**Our ref:** SL/2023/122661/05-L01  
**Your ref:** EN010128  
**Interested party ref:** 20049138  
**Date:** 17 January 2025

**Application by Cory Environmental Holdings Limited (CEHL) for an Order Granting Development Consent for the Cory Decarbonisation Project  
The Examining Authority's written questions and requests for information (ExQ1)**

DRAWING TITLE:
**PROPOSED JETTY
INDICATIVE DRAWING
REGULATION 5(2)(o)
APPLICATION DOCUMENT
REFERENCE 2.12**

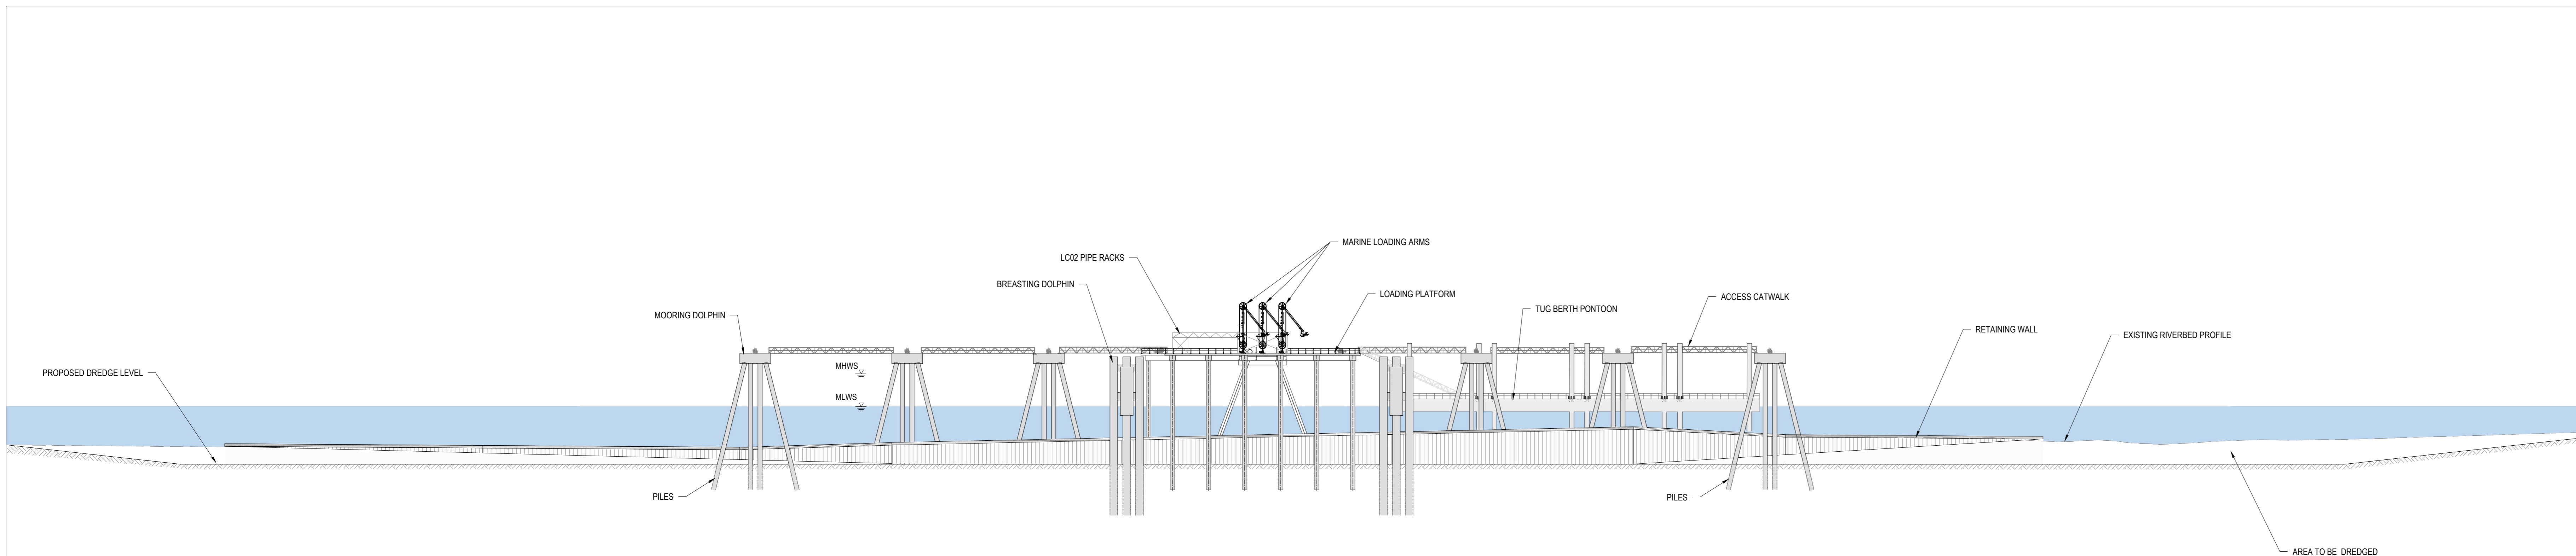
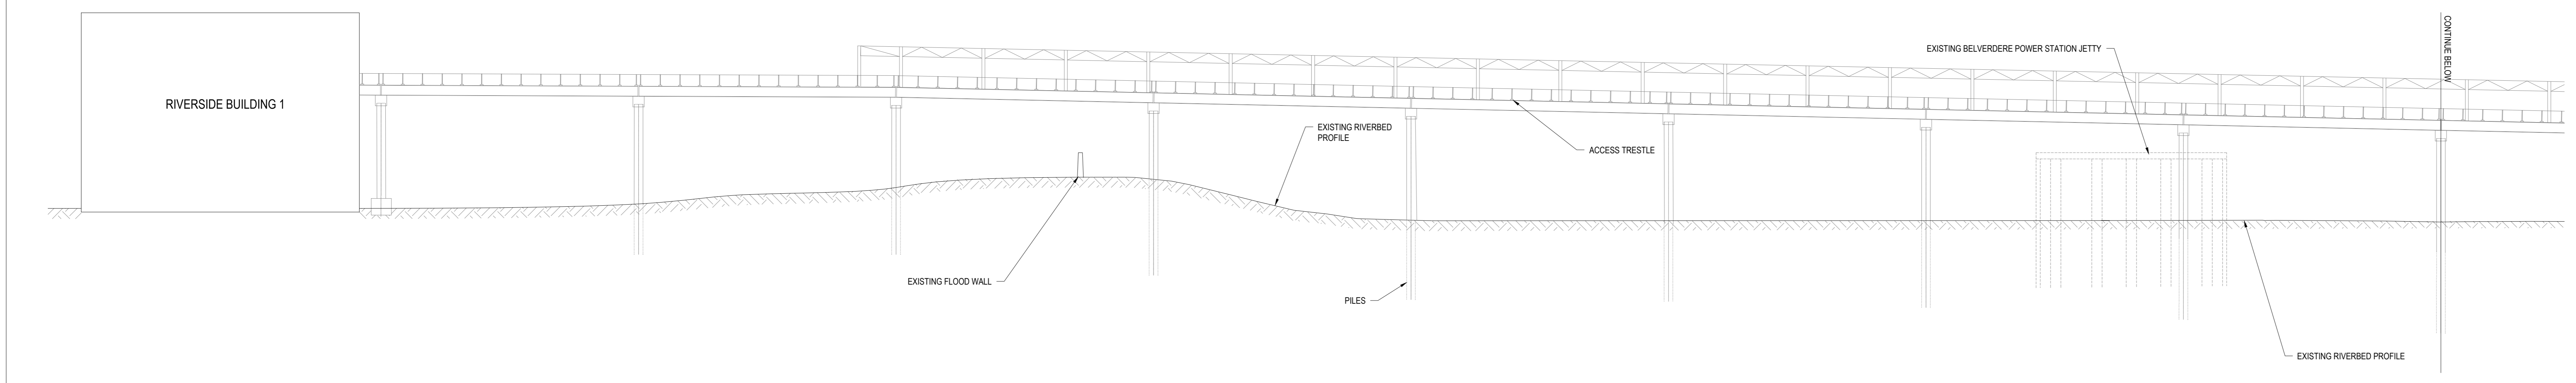
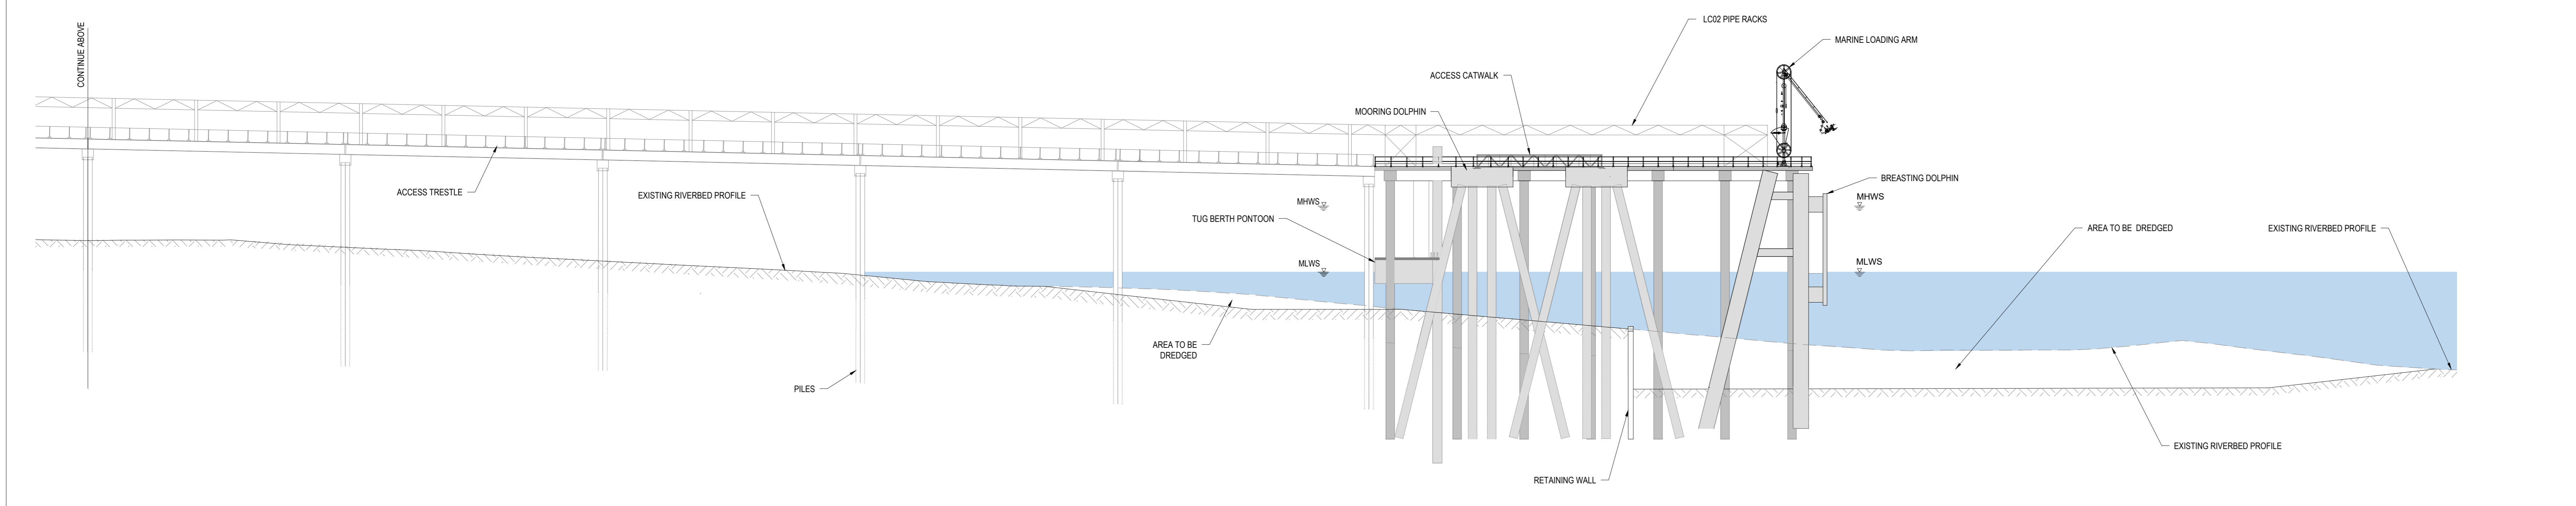
Where the Access Trestle crosses the River Thames Flood Defences the Environment Agency remains of the opinion that a clear 5 metre vertical clearance should be provided for operational access and improvement works relative to the existing flood defence crest level, as was provided by the underside of Middleton Jetty as part of the Riverside 1 scheme.
